**KIRKLEES METROPOLITAN COUNCIL
INVESTMENT & REGENERATION SERVICE**

DELEGATED DECISION TO DETERMINE PLANNING APPLICATIONS

Reference No:	2022/62/92535/E
Site Address:	631, Hunsworth Lane, East Bierley, BD4 6PU
Description:	Erection of single storey side and rear extension including front canopy and alterations to fenestration
Recommending Officer:	Nicole Helliwell

Officer Report

Proposed

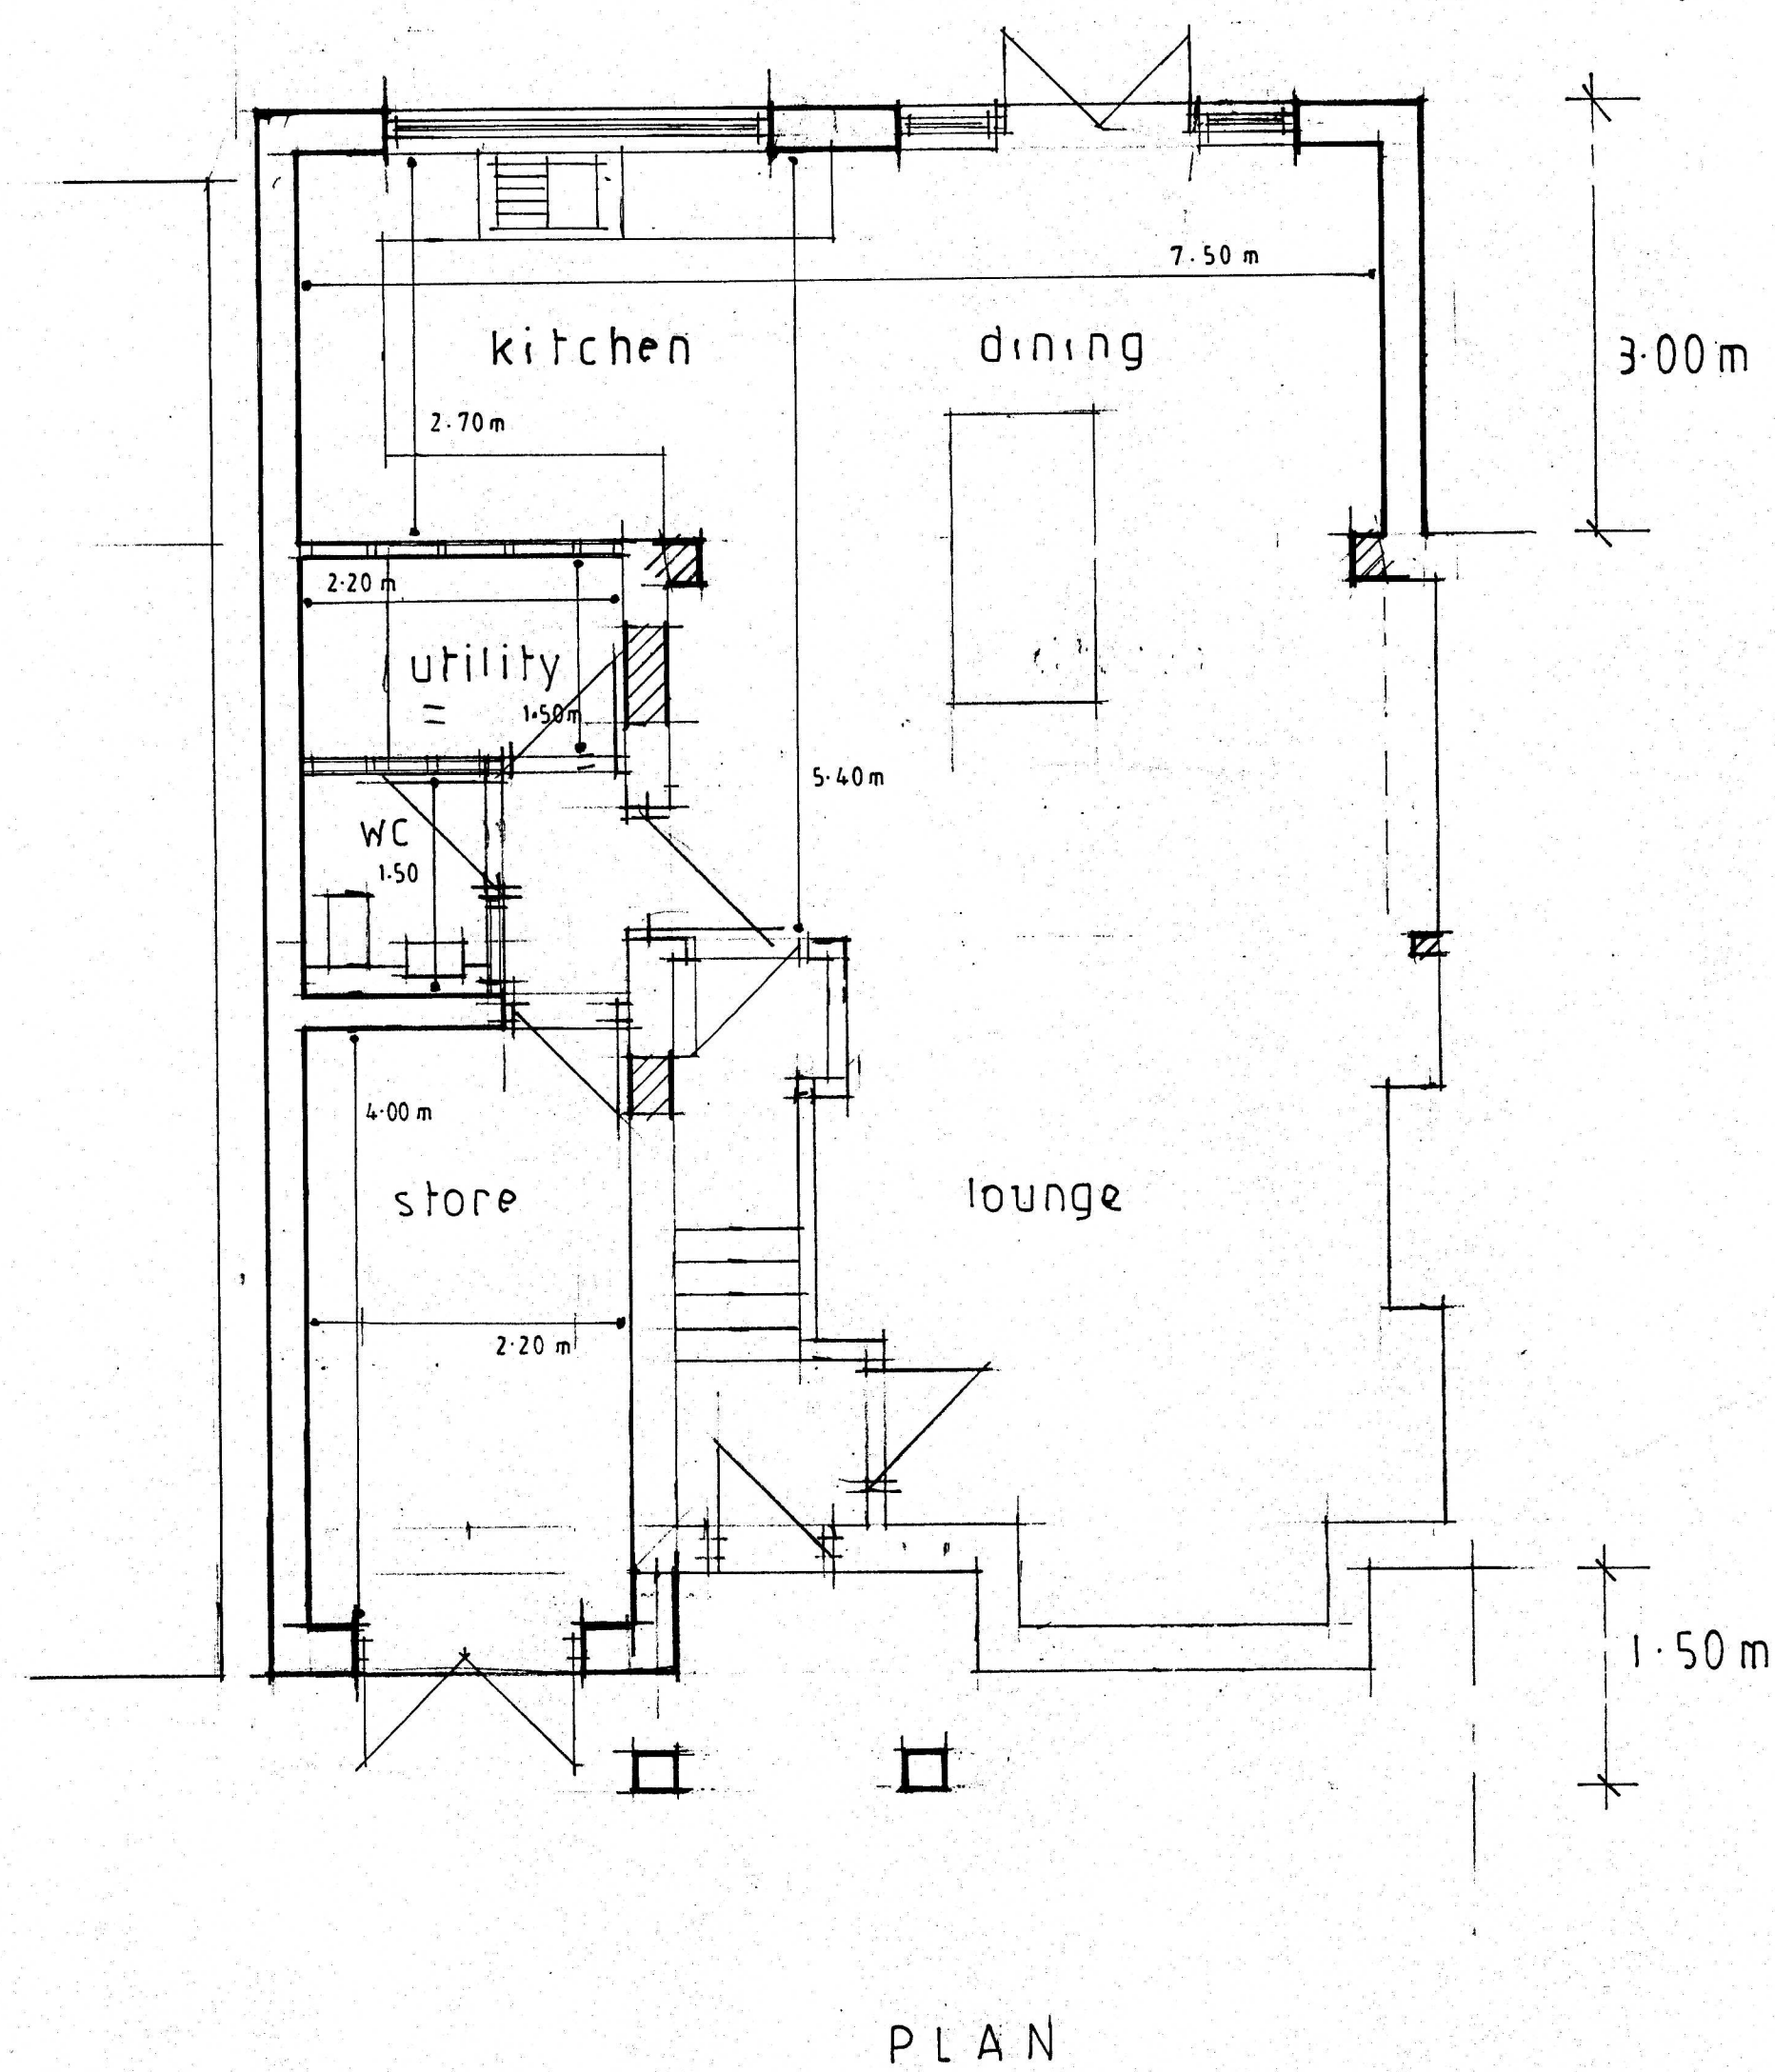
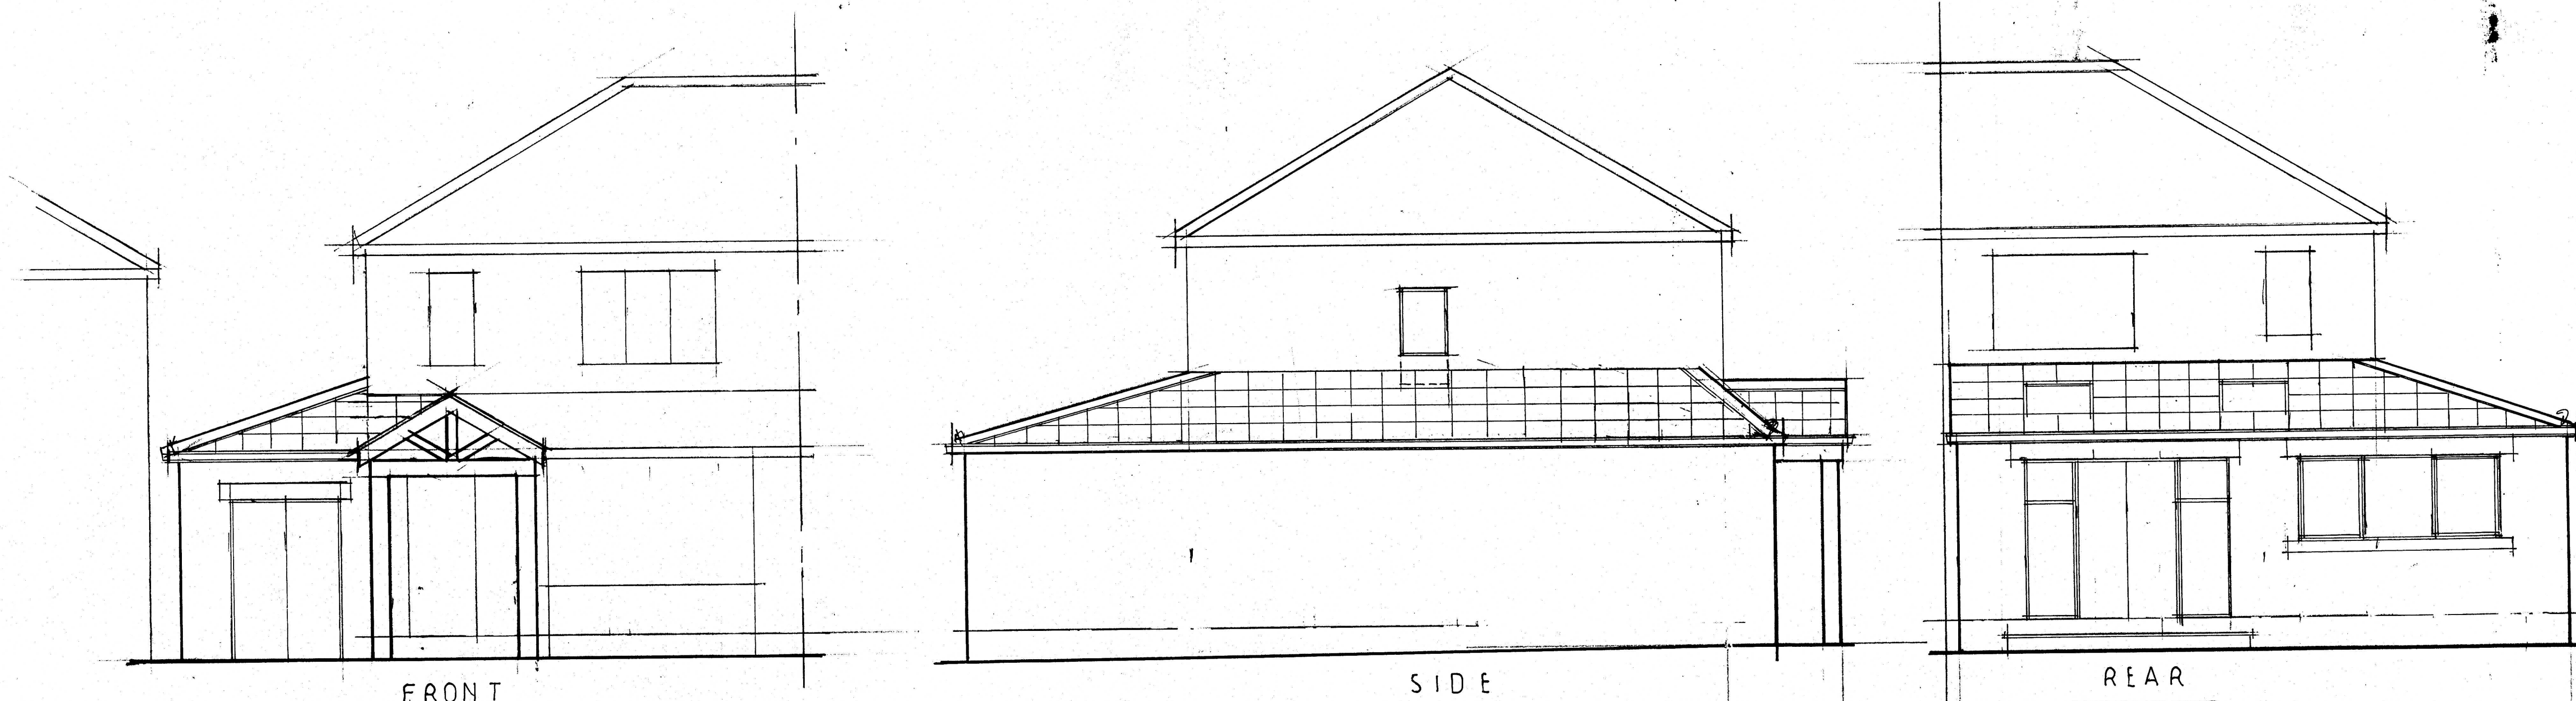
Amendments were sought during the course of the application. A request was made to set the proposed side extension back at least 500mm from the original building line and to set the proposed rear extension at least 500mm away from the boundary shared with no.633 Hunsworth Lane.

Although the revised drawings did not address all of the concerns raised, the agent did provide full justification as to why the proposed development

would be acceptable. The agent made reference to a number of properties along Hunsworth Lane which feature extensions that project forward of the original building line (no's 629, 627 and 623 Hunsworth Lane). Therefore, given that the street is characterised by extensions of a similar design, it is considered that the proposed development would not have any significant visual impact on the character and appearance of the host property and surrounding area and would be acceptable in terms of visual amenity.
